Submission No.			This cover letter is common to OPW Submission No.'s 213 to 240.	
Organisation Name or Name of Submitter			Office of Public Works (OPW)

Item No.	Section Ref.	Page No.	Observation Statement	TII Response
OPW Cover Letter - Re: Railway (Metrolink–Estuary to Charlemont via Dublin Airport) Order 2022 – Submissions by the Commissioners of Public Works in Ireland				
1	Cover letter - Legal Requirements	2	<p>Critical aspects of this project relating to physical construction methodologies have not yet been determined and, therefore, a full analysis of any impacts on properties is not possible. In that regards submissions are only possible and limited to the information that has been made available at this juncture.</p> <p>As noted above, the OPW is supportive of the Metrolink project. However, this is subject to all statutory requirements being complied with, in light of the Commissioners’ duties under the Commissioners of Public Works (Functions and Powers) Act 1996 and other Acts.</p> <p>Therefore, the confirmation of the Railway Order should ensure that the proposed Metrolink project properly falls into one or more of the criteria in s.116 of the 2008 Act.</p>	<p>TII wel

ST. STEPHENS GREEN STATION

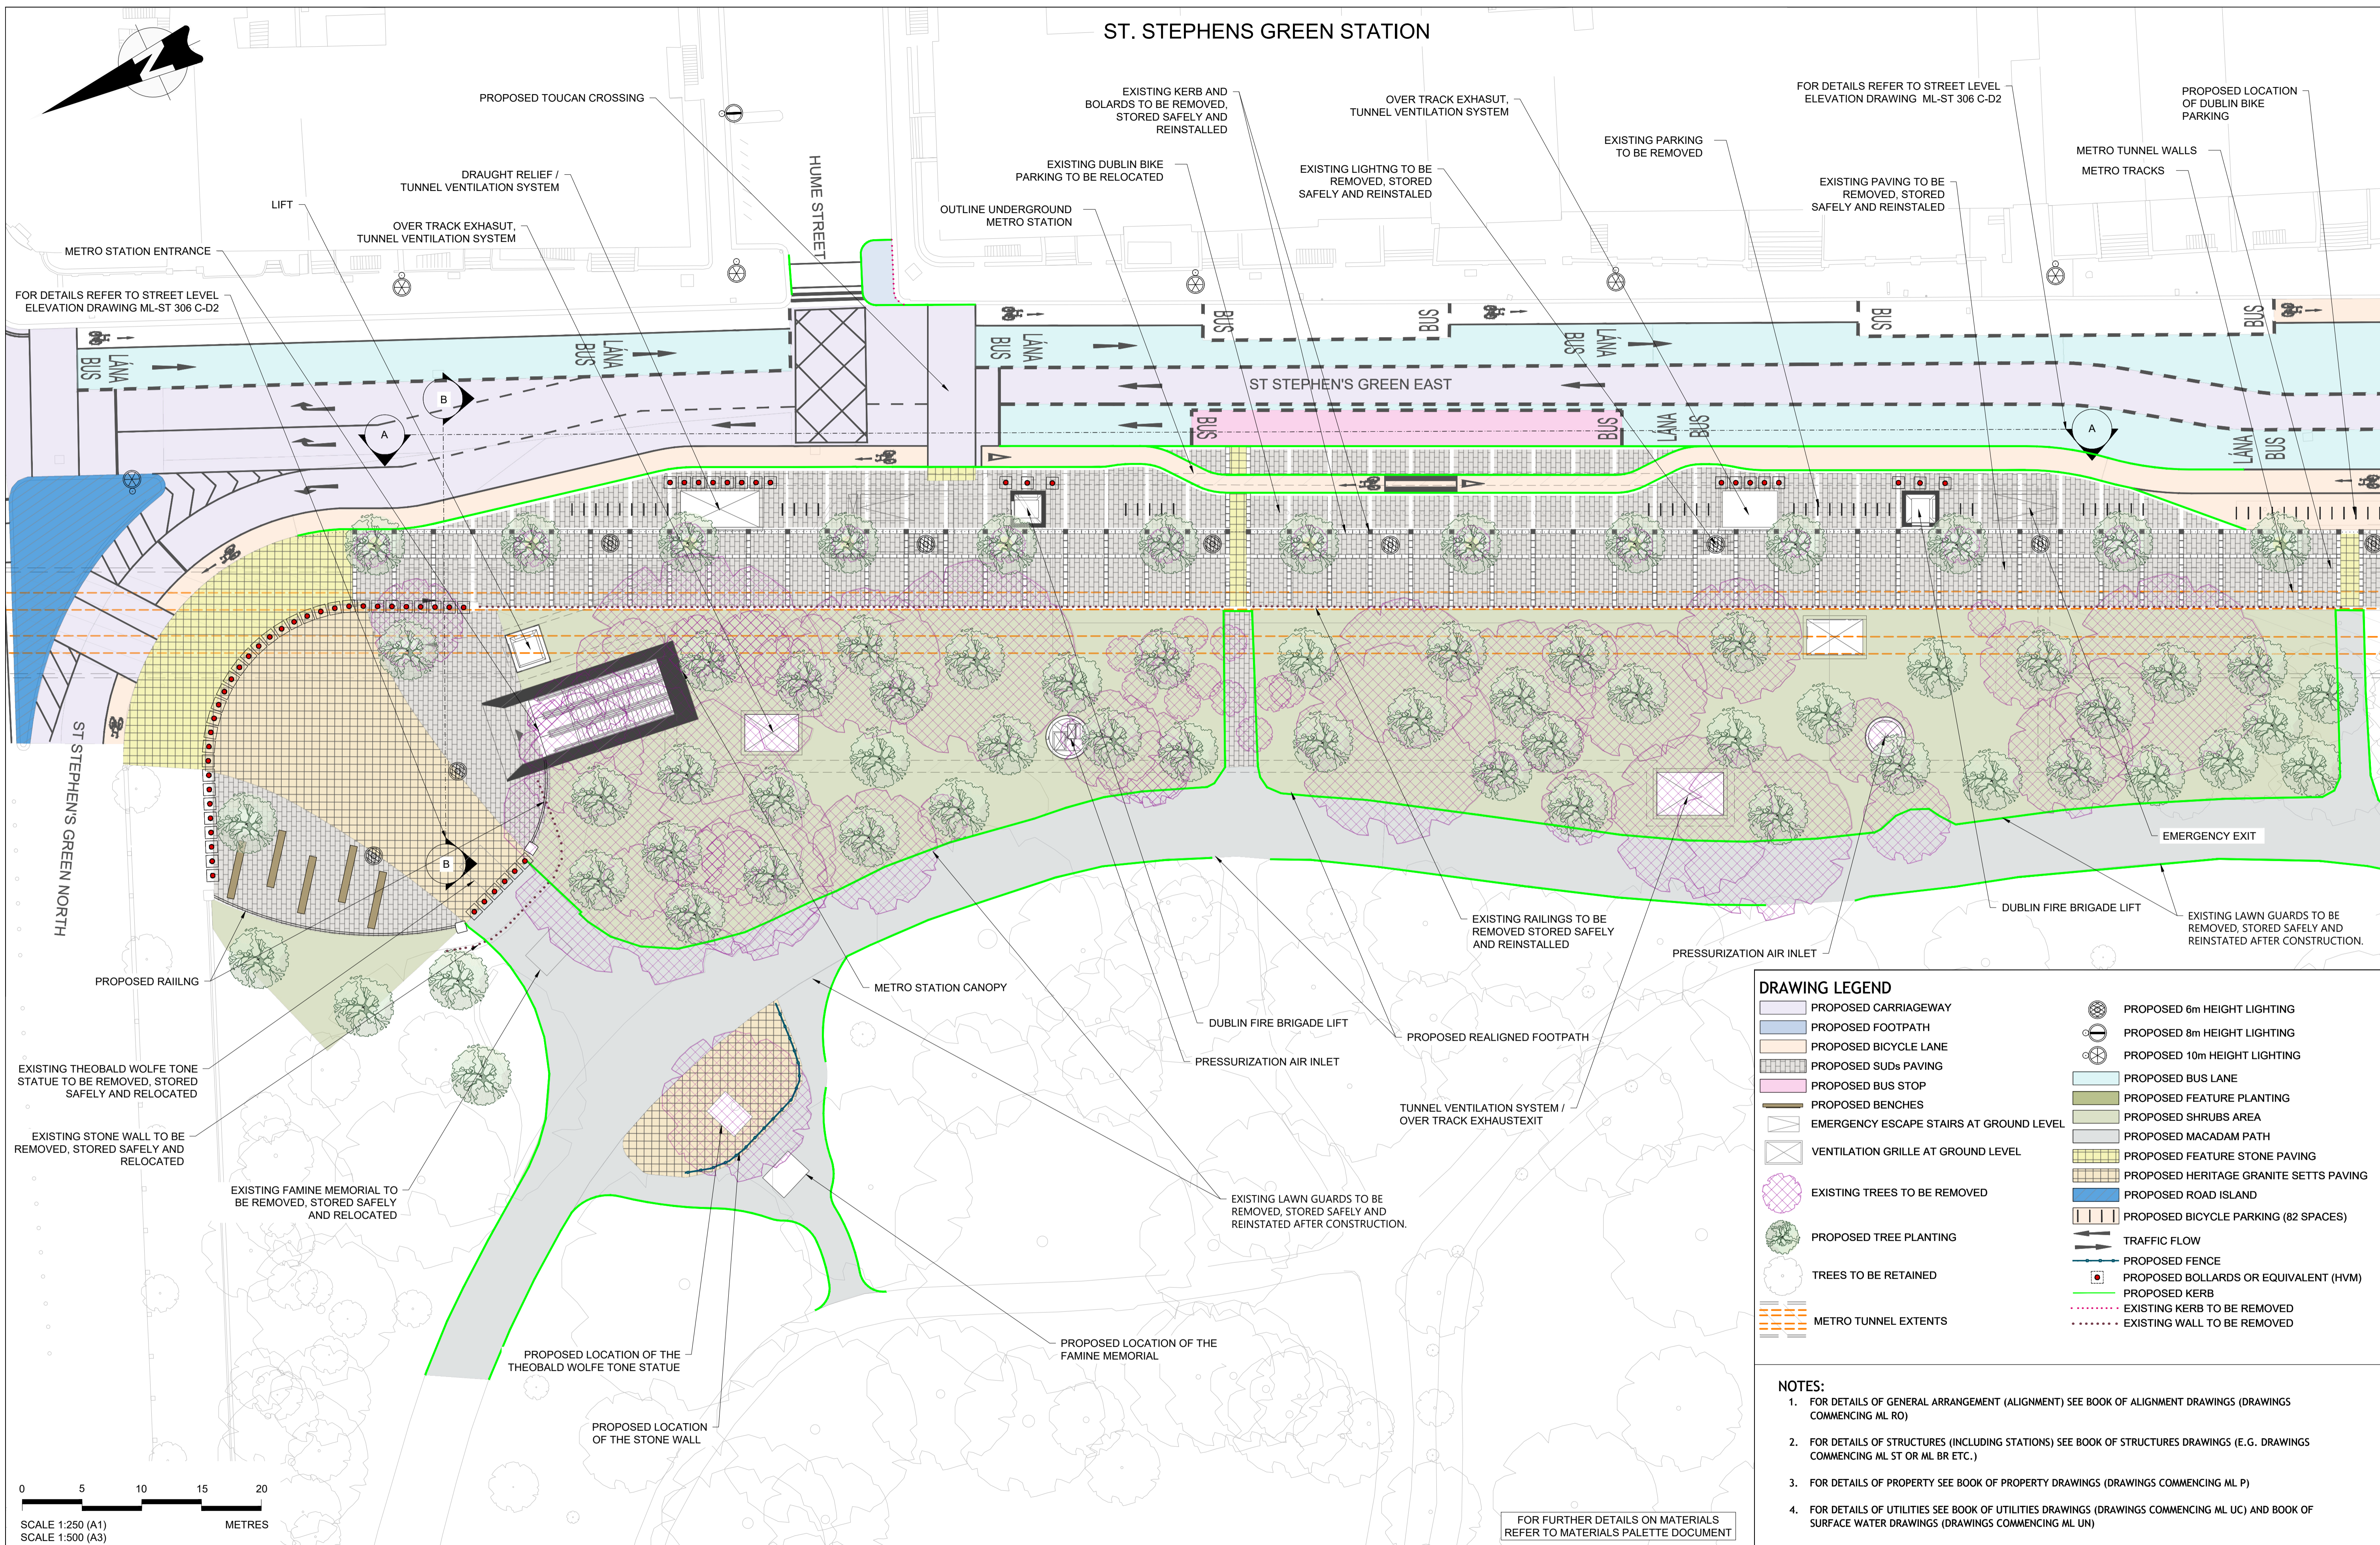
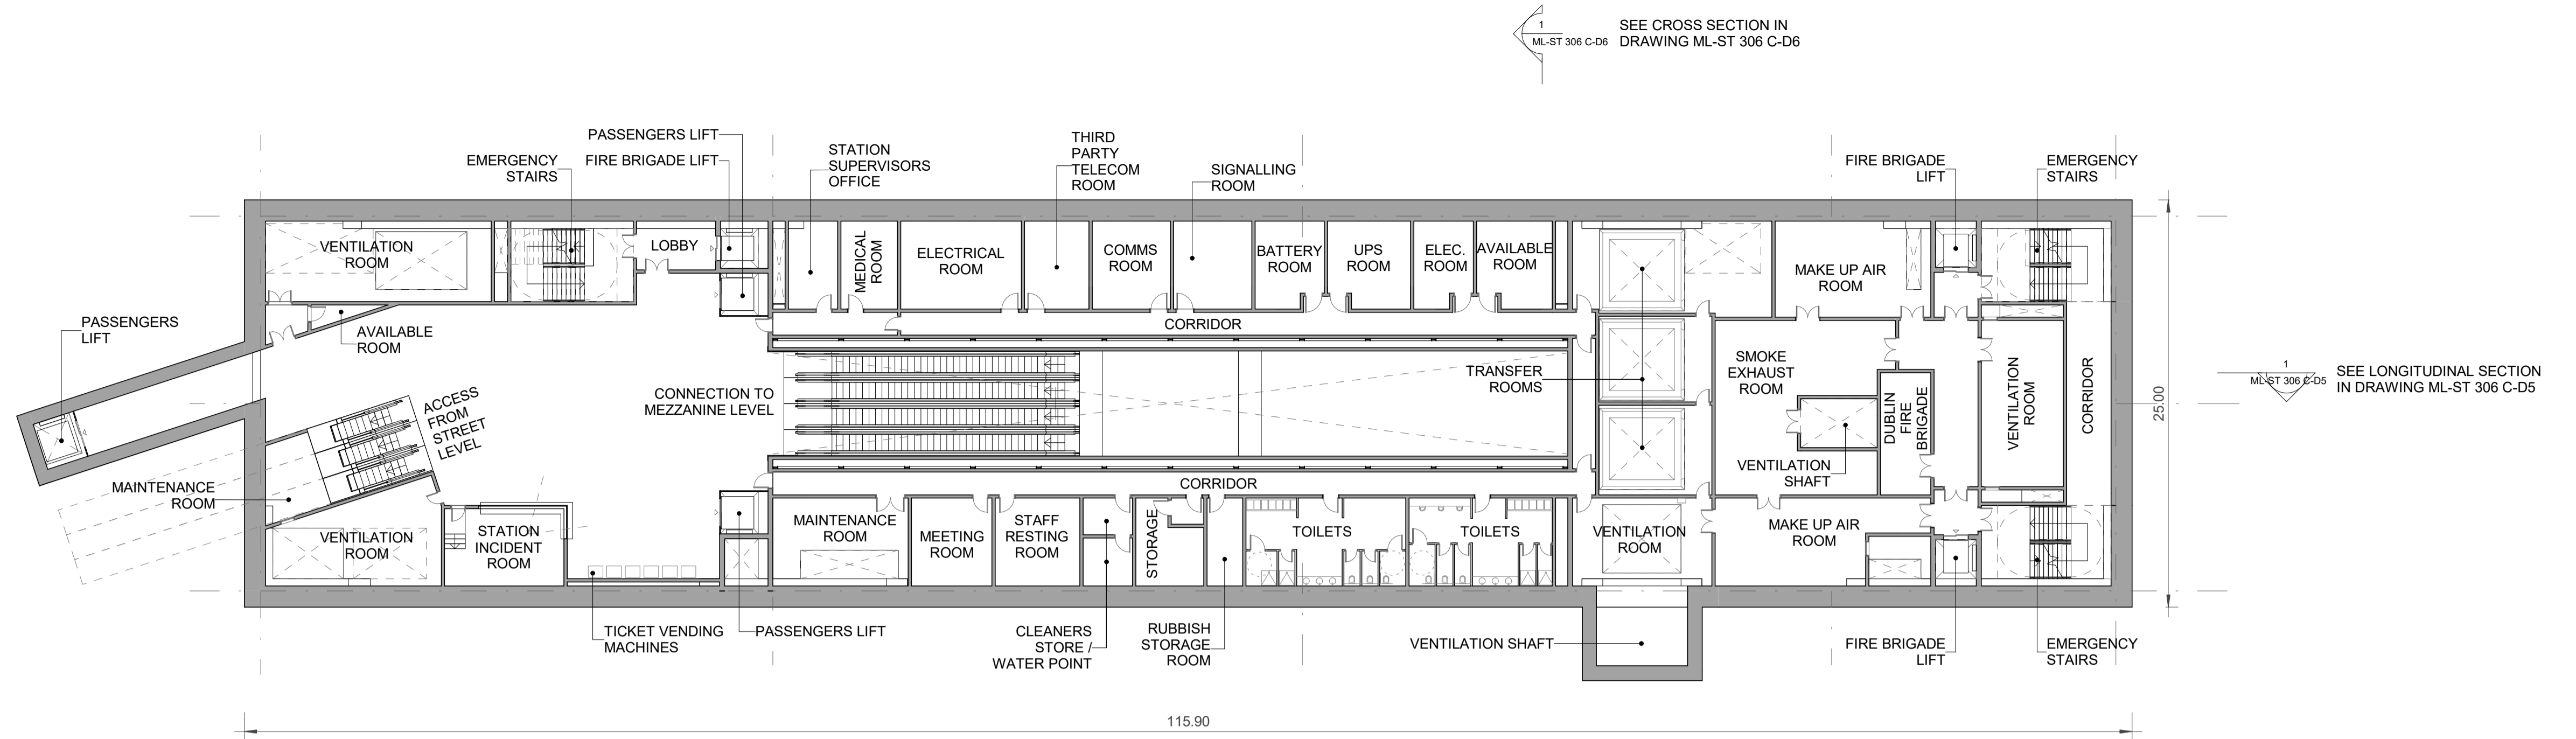
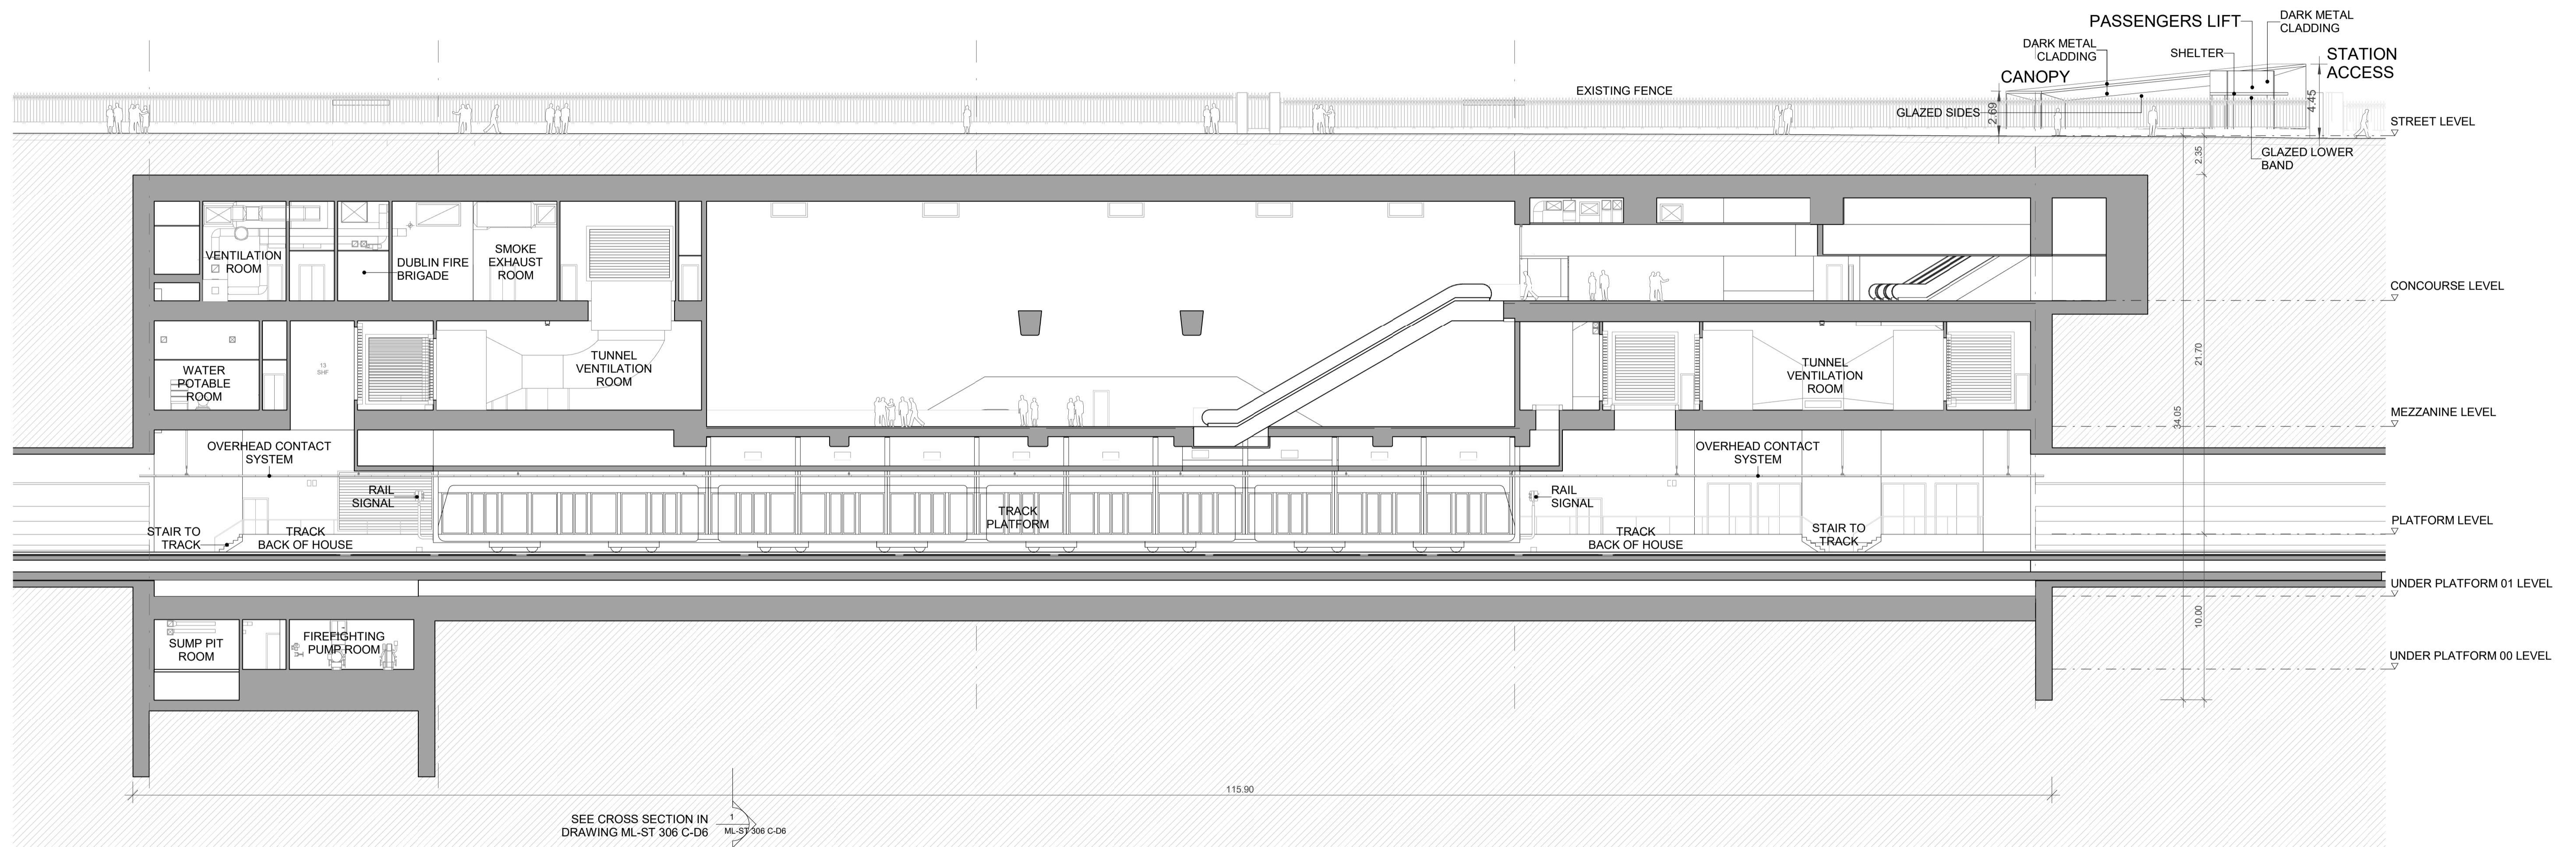
2	Executive Summary	N/A	<p>The current proposal is to site a station within the Green and the EIAR identifies the significant effect that this will have on this National Monument:</p> <ul style="list-style-type: none">• Chapter 25 Archaeology and Cultural Heritage characterises the effect as very significant direct negative (permanent) during the Construction Stage and very significant indirect negative during Operation Stage.• Chapter 26 Architectural Heritage characterises the effect as profound direct negative during the Construction Stage and very significant indirect negative during Operation Stage.• Chapter 27 The Landscape characterises the effect as very significant negative during the Construction Stage and very significant negative during Operation Stage.	<p>Options assessed include alternative MetroLink alignment options through this area with alternative station locations, alternative station locations at St. Stephen’s Green East, and alternative construction methodologies such as mining. The preferred station location of St. Stephen’s Green East was chosen as it minimises the potential impacts on the Park when compared to other options with a larger footprint in the Park. The preferred option occupies c. 5% of the Park area during the construction phase, reducing to just 0.2% of the Park during the operational phase. In addition, all heritage features such as monuments, railings, bollards, and paving stones can be fully reinstated following the construction phase.</p> <p>Appendix A 7.5 to the EIAR presents an analysis of the alternative construction methodology of mining the station which would allow for construction of the station with a smaller footprint at ground level. However, these options were ruled out as they would increase the construction phase (and as a result environmental impacts) by between 2 and 3.75 years and they would ultimately make it not possible for the Project to achieve its objectives of providing a high quality operational station.</p> <p>The location of the station has been chosen and carefully designed to ensure that St Stephen’s Green East continues to function as an important transport route, as an important corridor for critical utilities such as water, electricity and sewage, and as an important location for commercial and business activities. Ensuring this critical functionality on this side of St. Stephen’s Green would have been prolonged and very difficult to achieve with Location 8 that was located entirely outside of the Park. This option also negates the potential for direct impacts on properties to the east side of St Stephens Green East road, on critical utilities including a major Victorian sewer, and on the roadway which is an important access route to the city centre, particularly for public transport.</p> <p>It is acknowledged in Chapter 27 of the EIAR that the reinstatement of trees removed will take a significant period of time to re-establish. However on completion of the construction phase, reinstatement of heritage items and replanting (and reestablishment) of trees, TII maintains that the proposed St. Stephen’s Green Station will enhance this area by providing Dubliners and visitors alike with high quality public transport access to St. Stephen’s Green and to this area of the city, thereby reducing car dependency, noise levels and improving air quality, while allowing citizens to enjoy St Stephen’s Green long into the future.</p>

5	Executive Summary	N/A	<p>The OPW notes that in The St. Stephen's Green Station – Mined Options Report (EIAR Appendix A7.5), the current preliminary design performs worst with “regards to ‘Property Impact on SSG Park’, ‘Biodiversity’, ‘Landscape and Visual’, ‘Archaeology/Cultural Heritage’, and ‘Architectural Heritage’ criteria”.</p>	<p>When TII have evaluated alternatives and options, including for St. Stephen's Green Station, impacts and benefits, both short-term temporary construction (considering the operational life span of the Project), and long-term permanent (operational phase of the Project) have to be carefully balanced, considering a wide range of criteria that cover Project Objectives, Environment, Engineering and Economy (E.g. programme and risk).</p> <p>It is not appropriate to focus solely on a particular evaluation criteria in isolation since this will not result in the optimum solution / option being selected. In the case of St. Stephen's Green Station, while TII acknowledge that the preferred station location and construction methodology for the station is not the least environmentally impactful solution for St. Stephen's Green Park, when this is balanced and considered against the long-term strategic need for and operability of the Station / MetroLink, the mined solutions are deficient in terms of; a construction programme resulting in a significant increase in the duration of MetroLink construction and environmental impacts, and not achieving the project objectives of providing a high-quality operational station, (deeper station, increased passenger walking distances and a adverse impacts on the station ventilation strategy) resulting in a very long-term permanent degradation of the MetroLink Project. This is compared to what TII would consider is a temporary impact to a very limited area of the Park that can be mitigated, and in the permanent long-term case the Park can be returned to its existing condition.</p> <p>Attention is also drawn to EIAR Chapter 7, Consideration of Alternatives of the EIAR, and in Appendices to the Chapter (A7.3, A7.5, A7.7 and A7.8). It is very important to recognise and is evident, that a significant level of analysis was undertaken to identify alternatives, 16 alternatives (10 cut and cover, 6 mined) in total were considered. Each were assessed against multiple criteria to inform the determination of the preferred station location for St. Stephen's Green. This analysis considered potential environmental effects on St. Stephen's Green Park, potential effects on buildings on the east and north sides of St. Stephen's Green, on traffic and transport along St. Stephens Green East, and on critical utilities serving large areas of the city located under the road at St. Stephen's Green East. The analysis identified that the proposed station location on St Stephen's Green East partially under St. Stephen's Green Park is the preferred option because it effects just 5% of the Park area during the construction phase, reducing to 0.2% of the Park area following full re-establishment, whilst providing a station that operationally meets the requirements of the Project over its lifetime. In addition, all heritage features such as monuments, railings, bollards, and paving stones can be fully reinstated following the construction phase. This option also negates the potential for direct impacts on properties to the east side of St Stephens Green East road, on critical utilities including a major sewer (a critical piece of infrastructure) serving the Dublin population, and on the roadway which is an important access route to the city centre, particularly for public transport.</p>

Submission No.			239		
Organisation Name or Name of Submitter			Office of Public Works (OPW)		
Item No.	Section Ref.	Page No.	Observation Statement	TII Response	
OPW Cover Letter - Re: Railway (Metrolink-Estuary to Charlemont via Dublin Airport) - St Stephens Green Park					
12	Executive Summary	N/A	Section of St. Stephen’s Green directly affected by the Project, highlighted in red. Section of St. Stephen’s Green likely to be negatively impacted by the Project, highlighted in orange.	The image presented in the executive summary of the accompanying report is very misleading. It appears from the image and from the references in the submission to show "225 trees being potentially negatively impacted" and that the OPW have reviewed the Arboricultural impact assessment and identified that because trees have been surveyed as part of the project (225 of them), these trees are potentially going to be negatively impacted. This is not the case. The potential impacts identified within the relevant chapters of the EIAR are based on the identified fact that 64 trees will be felled (and replaced after completion of construction), and that all other trees within the Park will be retained and not be impacted. Furthermore the proposed construction of the station at St. Stephen's Green will occupy a maximum of 5% of the Park area and as such will not preclude the Park outside of this area being used as normal.
